Subject: Response To Application Number M/80/19/PL at Former Poultry Farm Land West of Yapton Road Middleton on Sea PO22 6DY

WEST SUSSEX COUNTY COUNCIL CONSULTATION

TO:	Arun District Council FAO: Anita Gardner
FROM:	Stephen Gee WSCC - Highways Authority
DATE:	4 October 2019
LOCATION:	Former Poultry Farm Land West of Yapton Road Middleton on Sea PO22 6DY
SUBJECT:	M/80/19/PL Demolition of the existing structures & redevelopment to provide a new 66-bedroom care home (Use Class C2) arranged over two storeys together with associated access, car and cycle parking, structural landscaping and amenity space provision.
DATE OF SITE VISIT:	
RECOMMENDATION:	Objection / More Information
S106 CONTRIBUTION TOTAL:	TBC

402.06594.00008:14.TR04.RevA.dwg

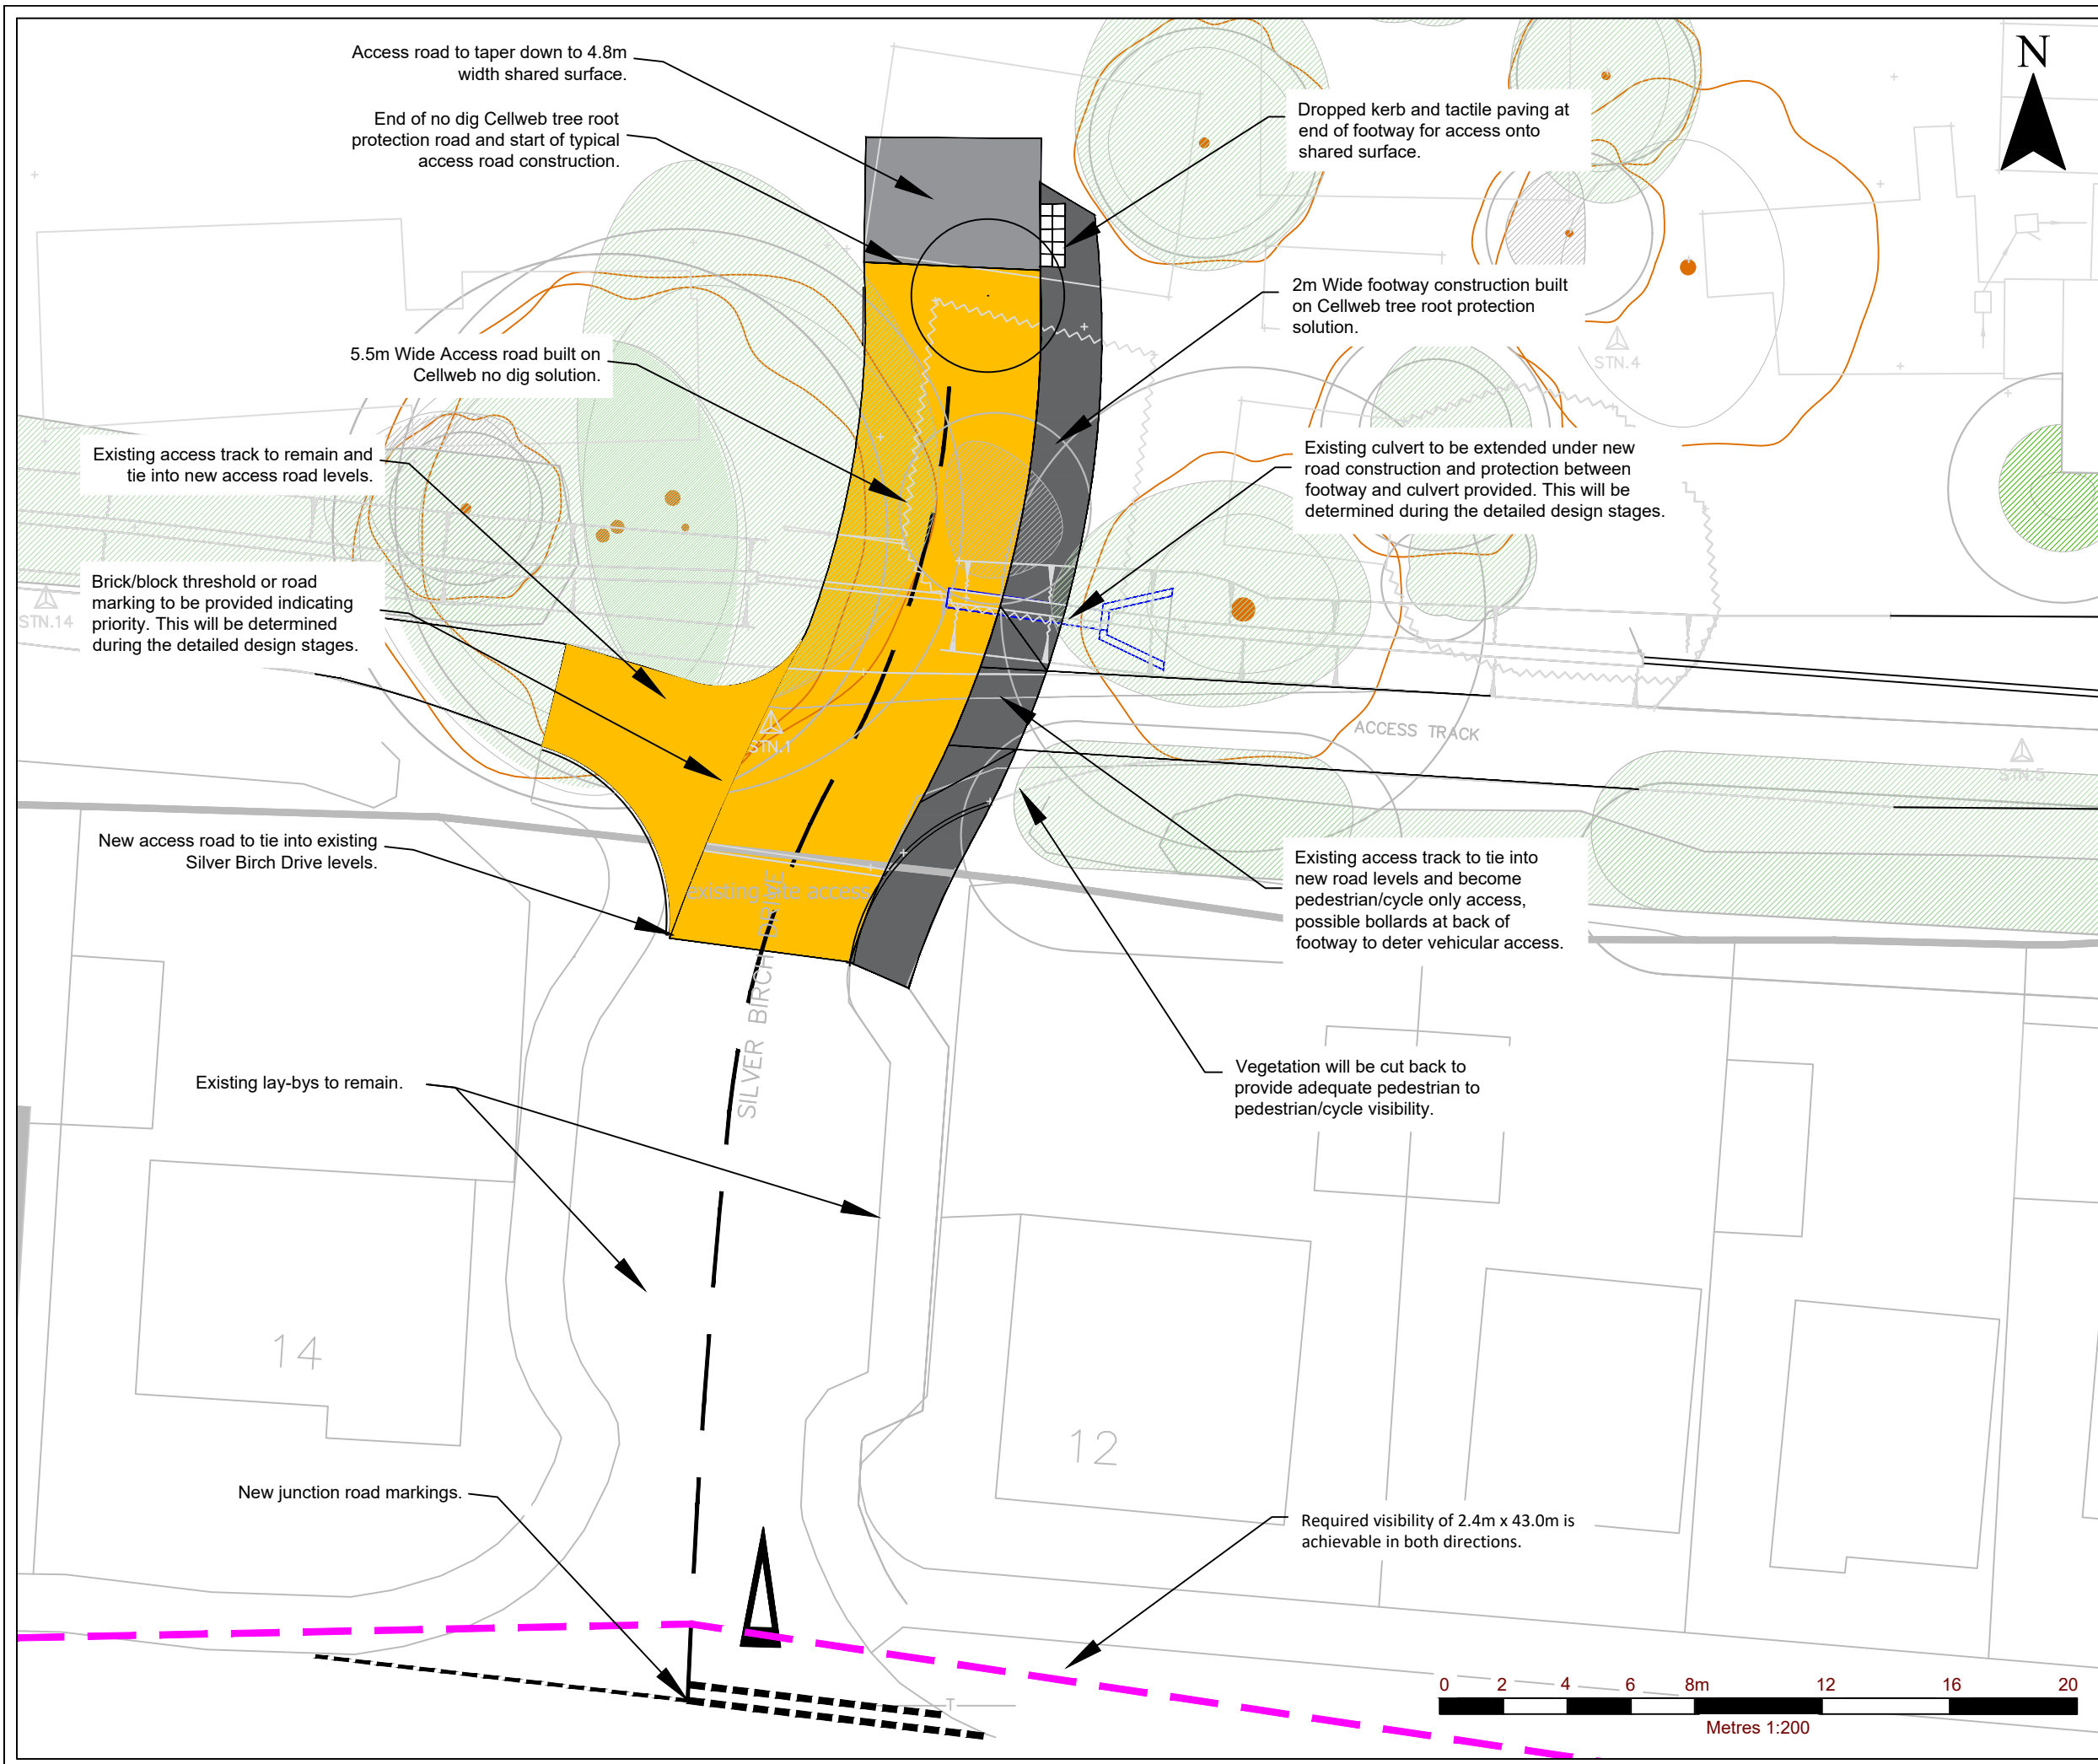
Access to the site is proposed from Silver Birch Drive utilising the existing cul-de-sac between no 12 and 14 Silver Birch drive as shown on the Proposed Site Access plan ref TR04. A 5.5m access road is to be provided which will then taper into a 4.8m wide shared surface within the site. The existing culvert would be extended under the new road construction and the existing laybys retained.

In line with the WSCC Road Safety Audit policy a stage 1 RSA should be provided.

An objection is raised to the proposal as a Stage 1 Road Safety Audit has not been provided with the application.
